DRB Application No.: 05DRB-01709 (SPS)  
Project Name: QUARTERS PLAZA OFFICE BLDG.  
Agent: Martin Grummer

**DRB CASE NO/PROJECT NO: 1001623**

Date: 15 November 2005  
To: Sheran Matson, DRB Chair  
From: Russell Brito, Senior Planner  
RE: Project # 1001623: 05DRB-01709 / 01710 / 01708

DRB-1001623      Item No. 9      Zone Atlas A-14

CARLOS TORREBIARTE
OFFICE BUILDING
PRELIMINARY
GRADING AND DRAINAGE PLAN

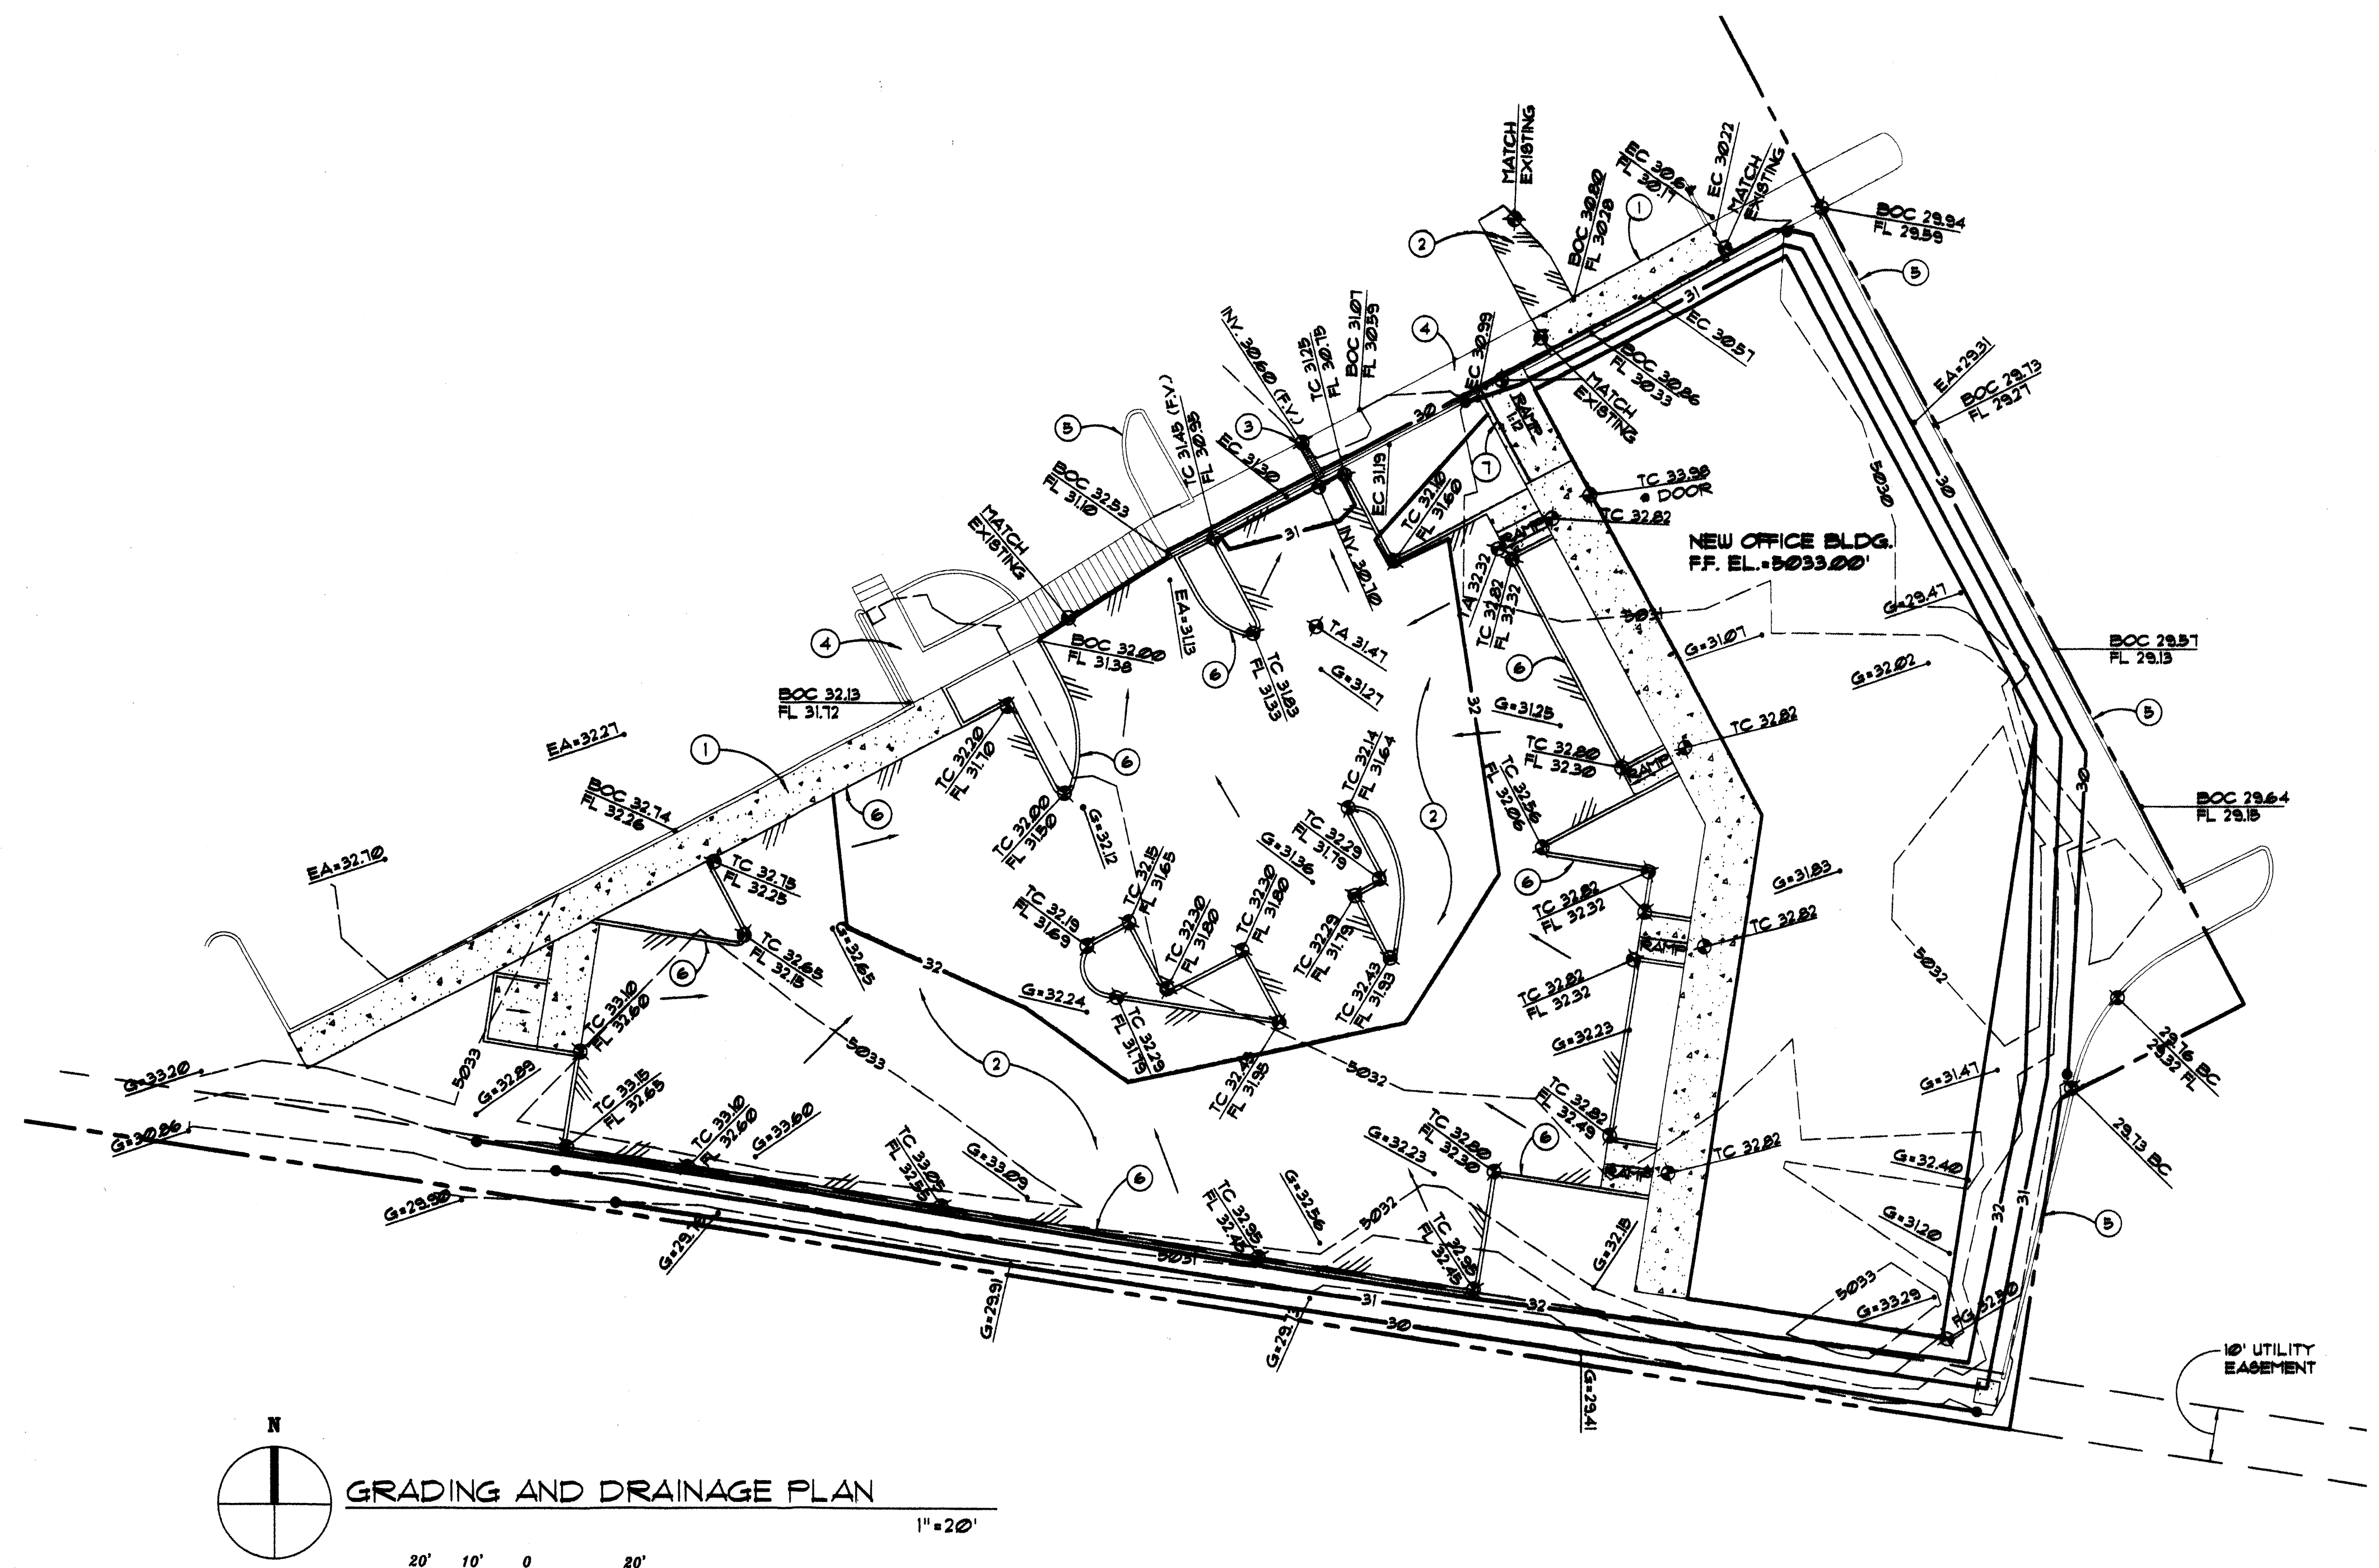
Need private drainage easements for ponds and maintenance agreements.

SHEET NO:
C1.1

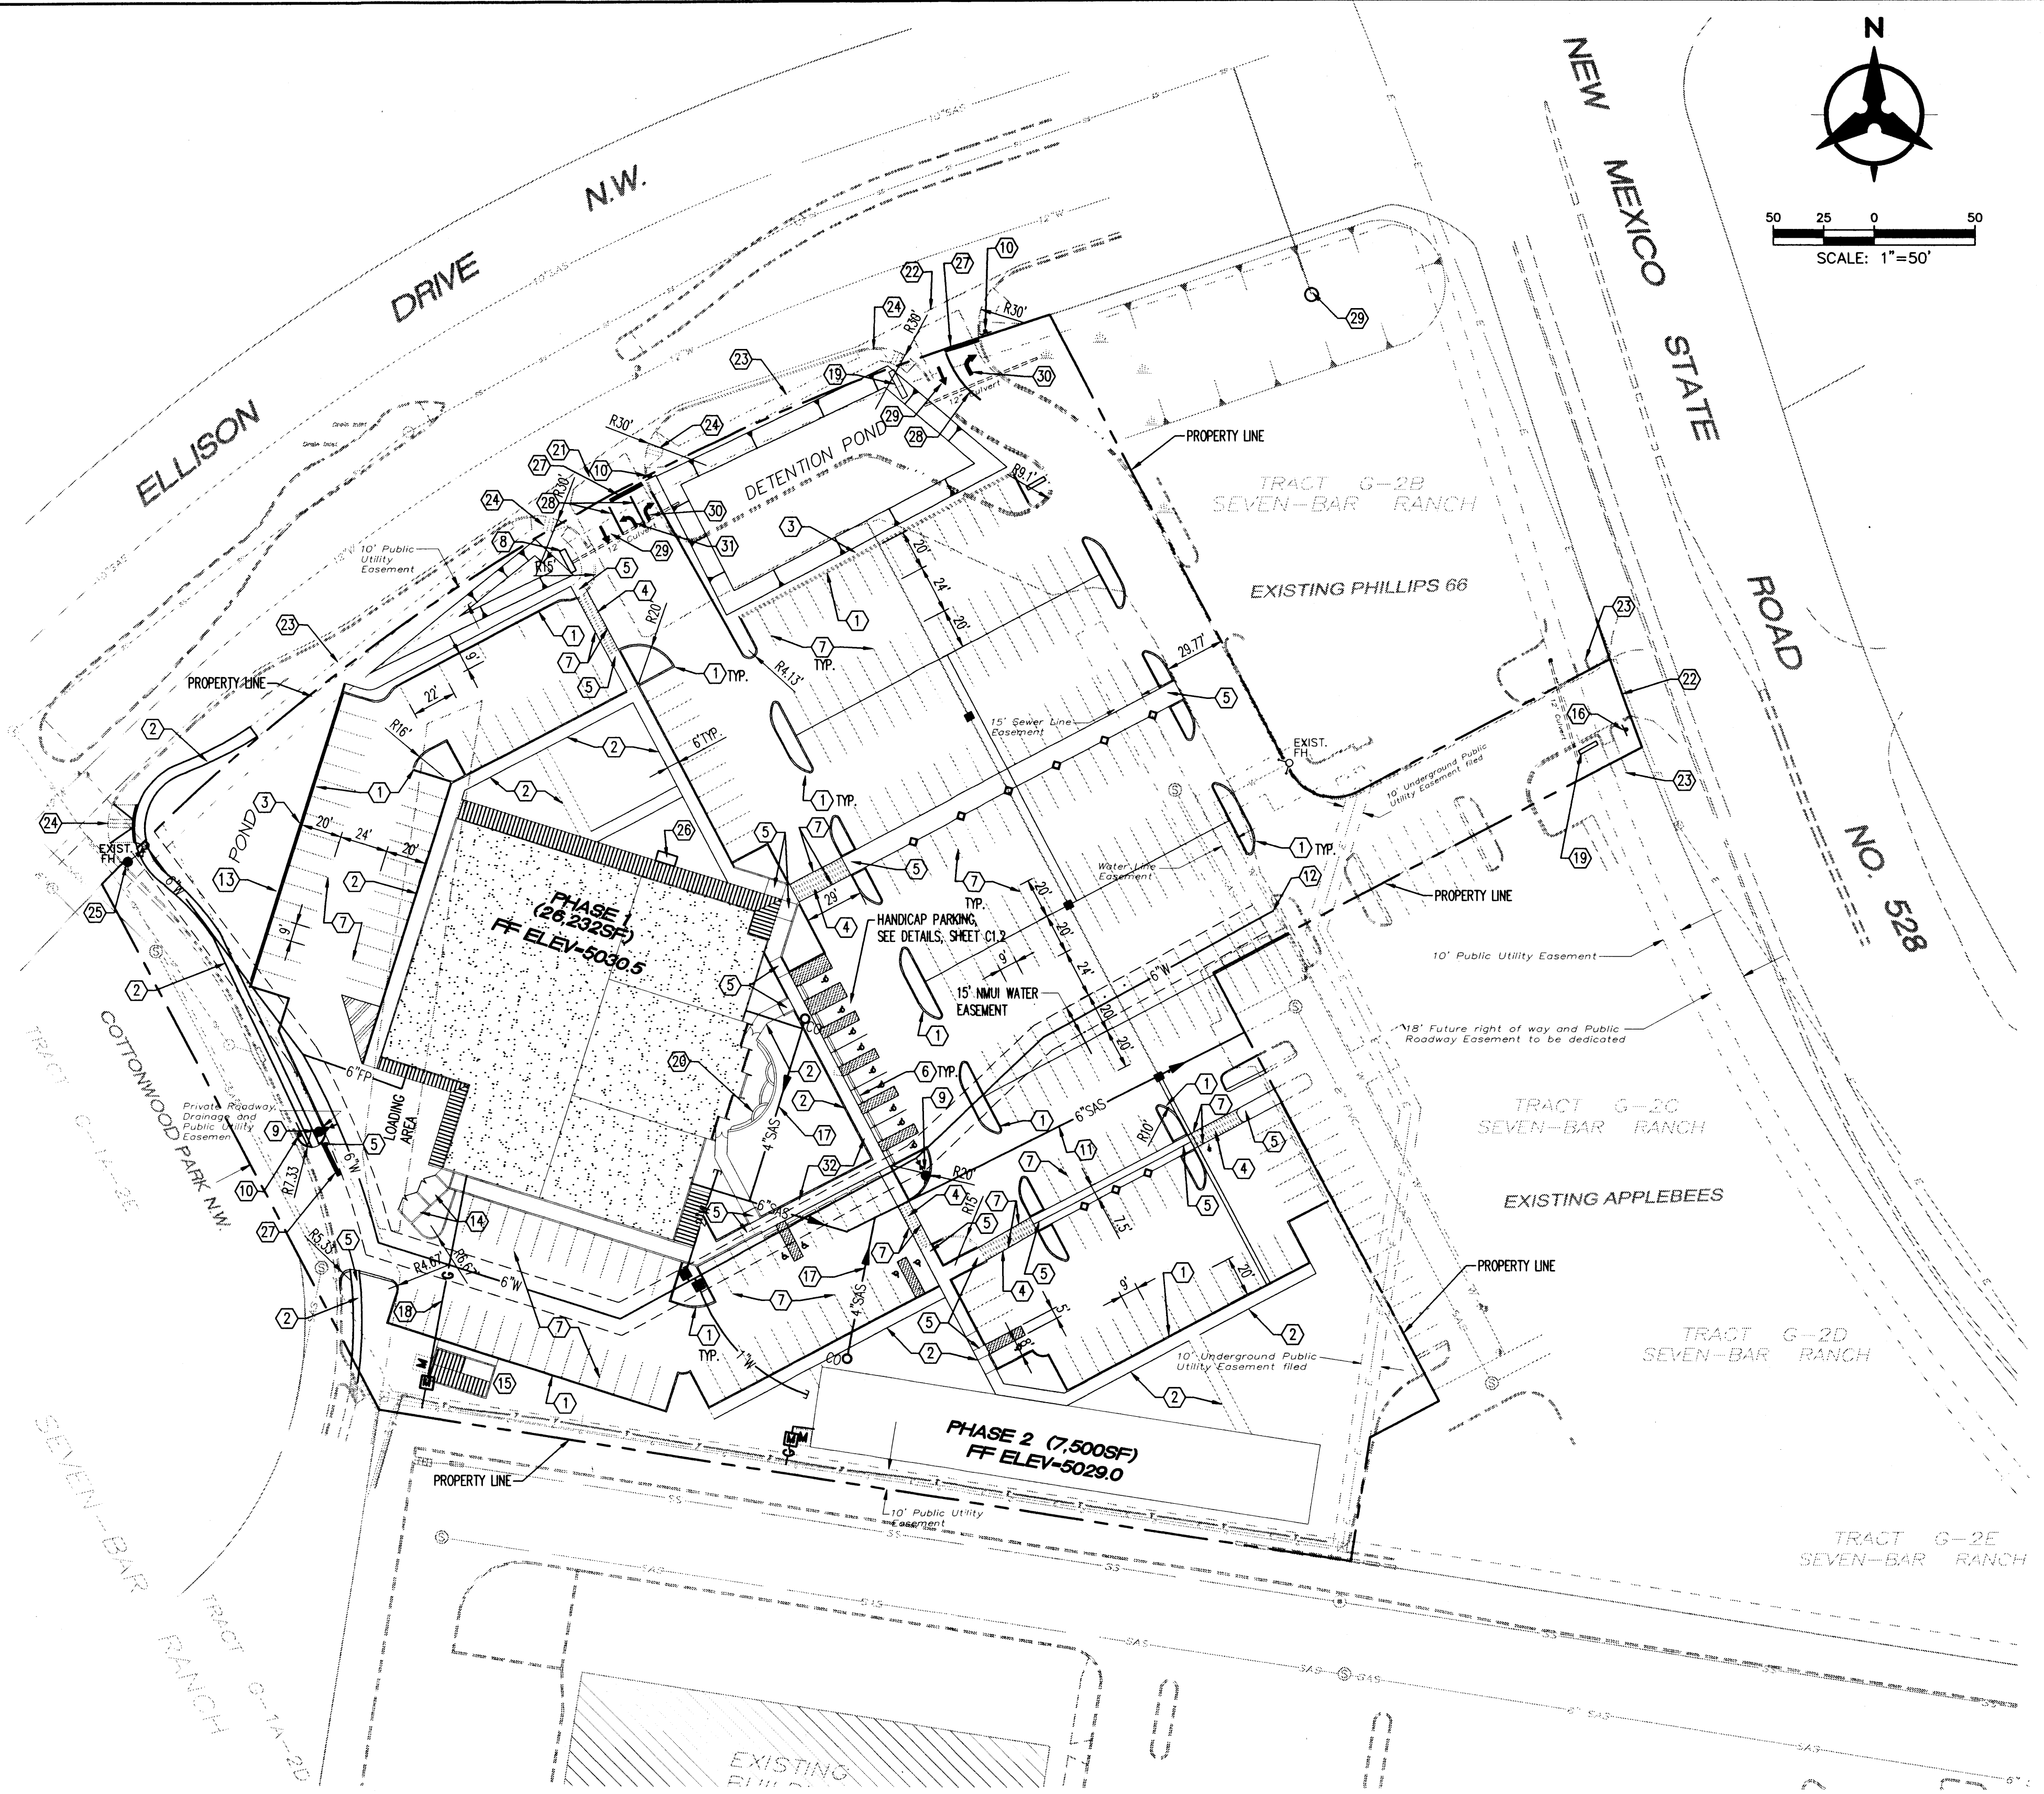
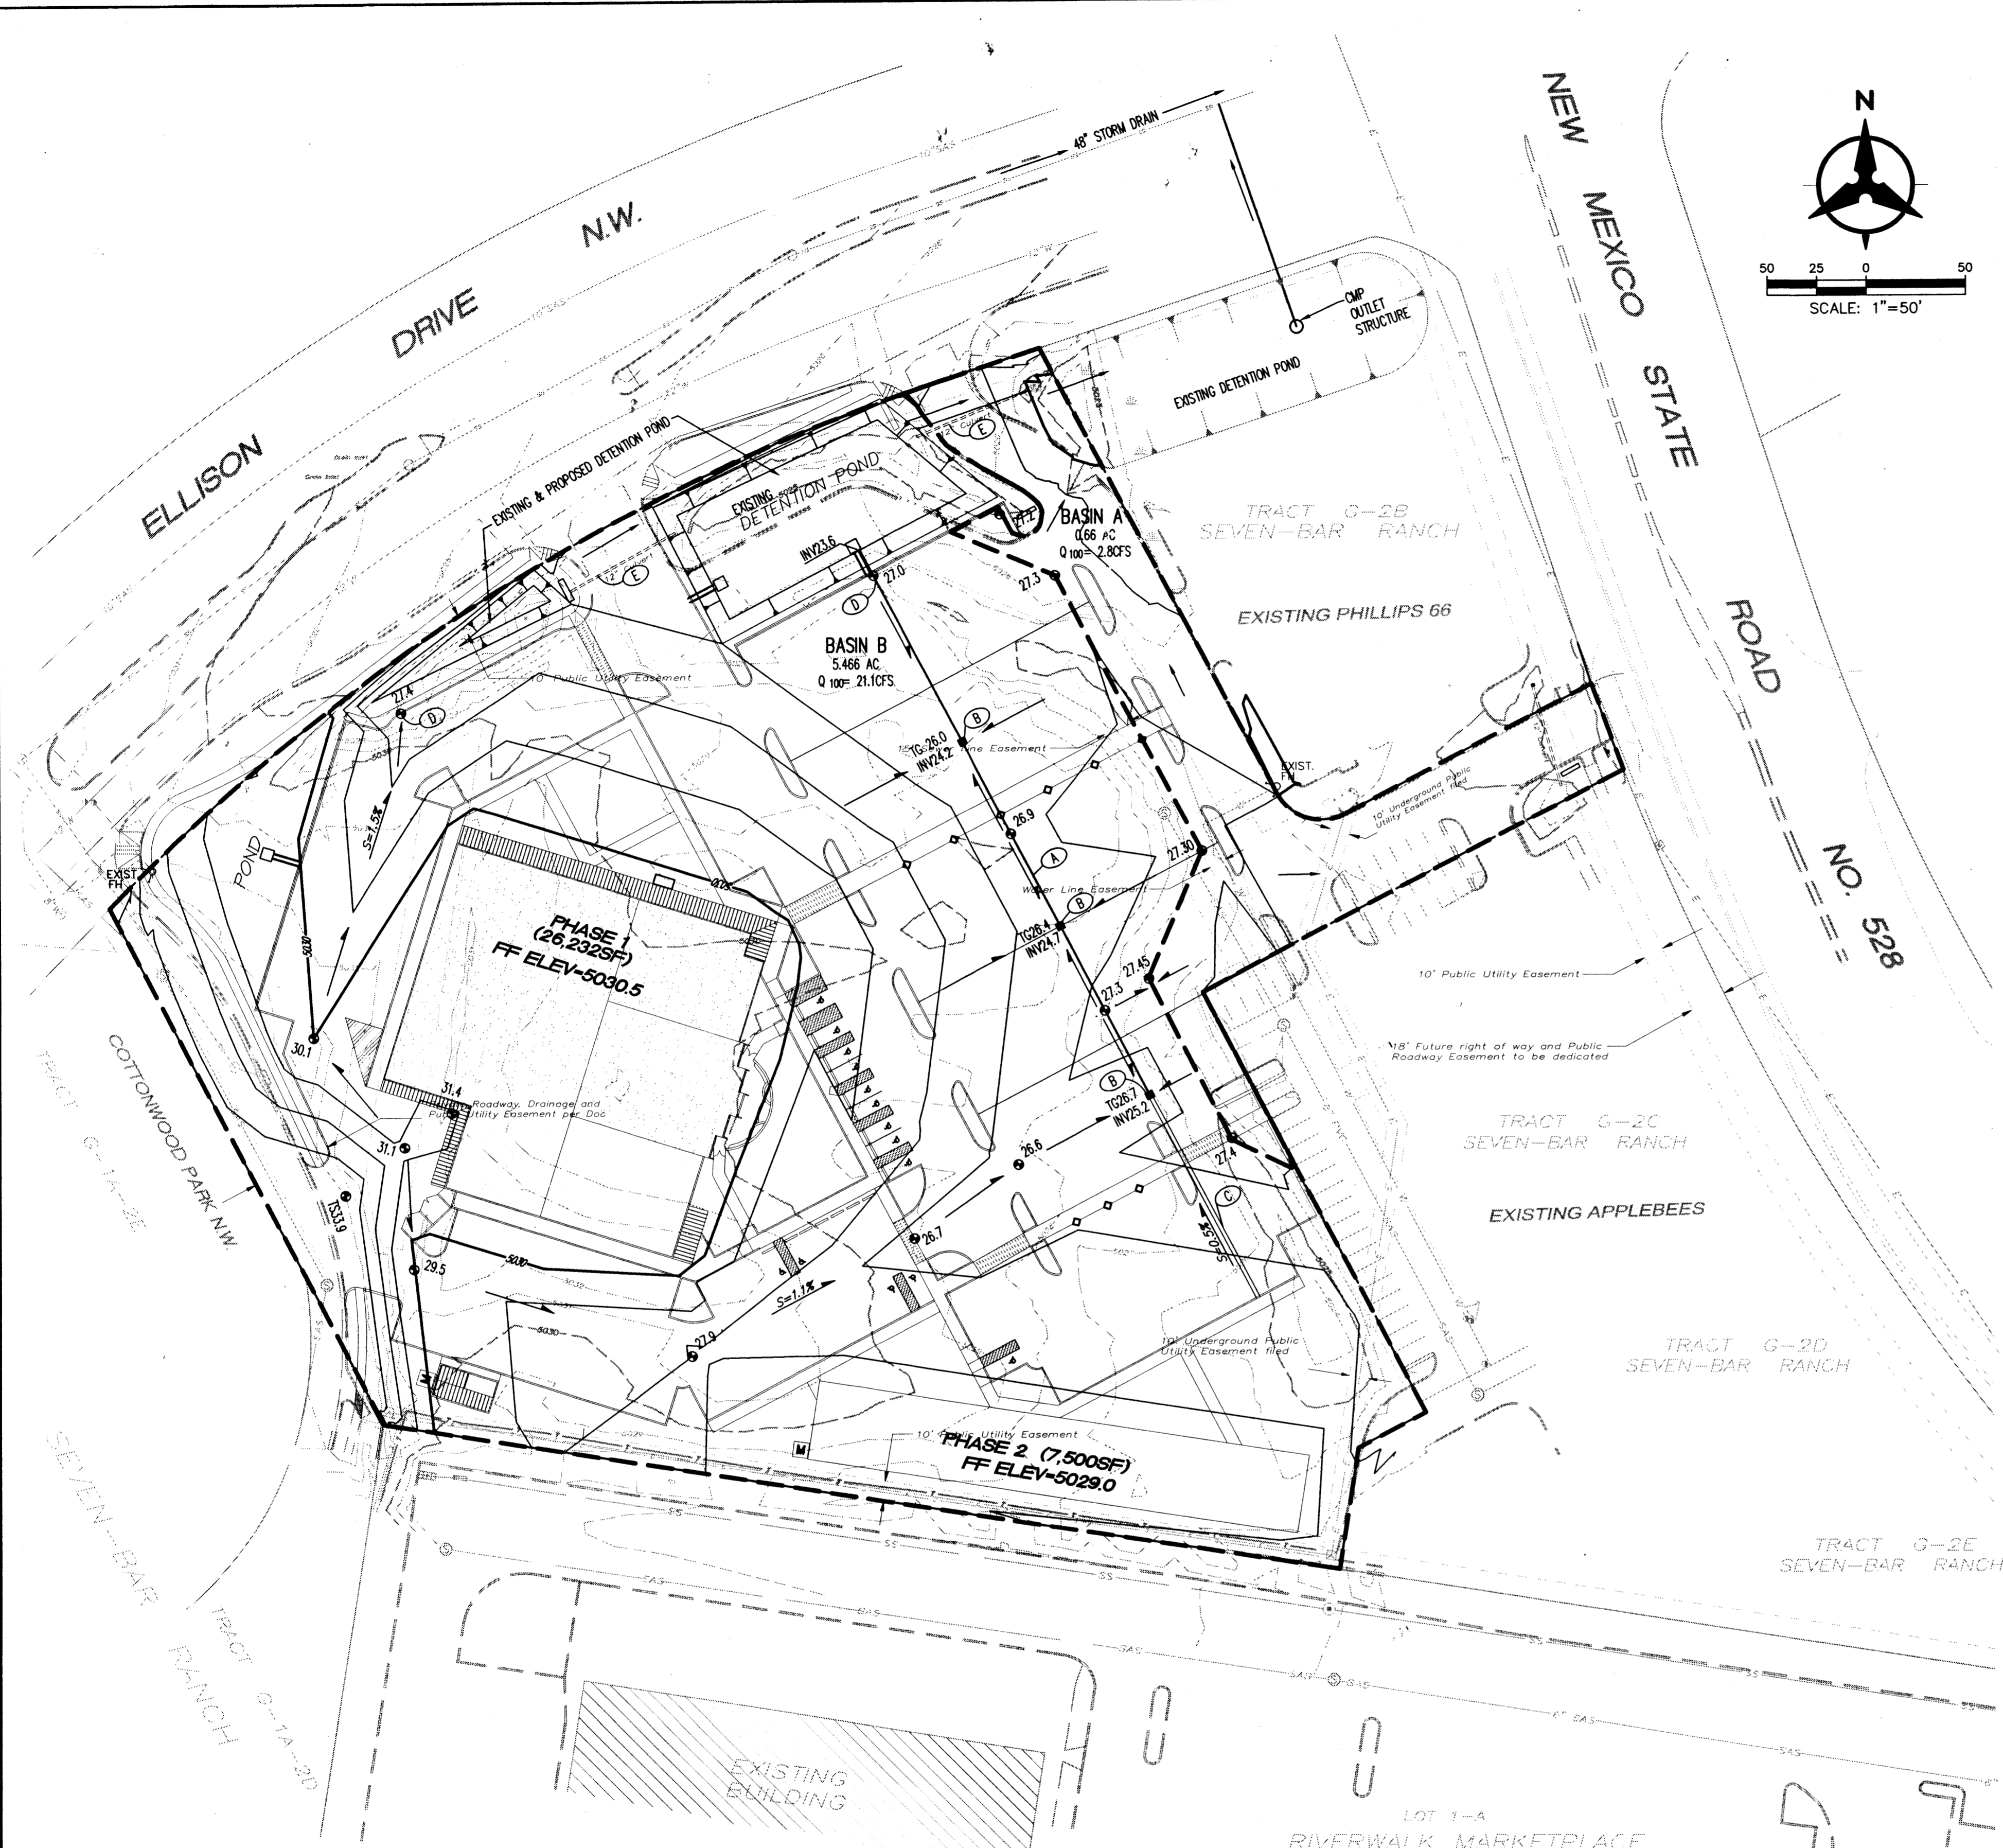
- Infrastructure list will be needed for the offsite improvements.
- Is Public Right-of-Way dedication on Cottonwood Park needed?
- Provide 24" white bar where stop sign is proposed.

- You have 6 feet of existing sidewalk at Ellison Drive entrance?
- Provide all keyed notes on sheet C1.1.
- Strip all pedestrian crossings with 4" solid white stripe.

- A minimum radius of 15 feet is needed on all aisle islands.
- Label all wheelchair ramps either unidirectional or multidirectional ramp.
- Make sure all radii's are labeled and dimensioned.
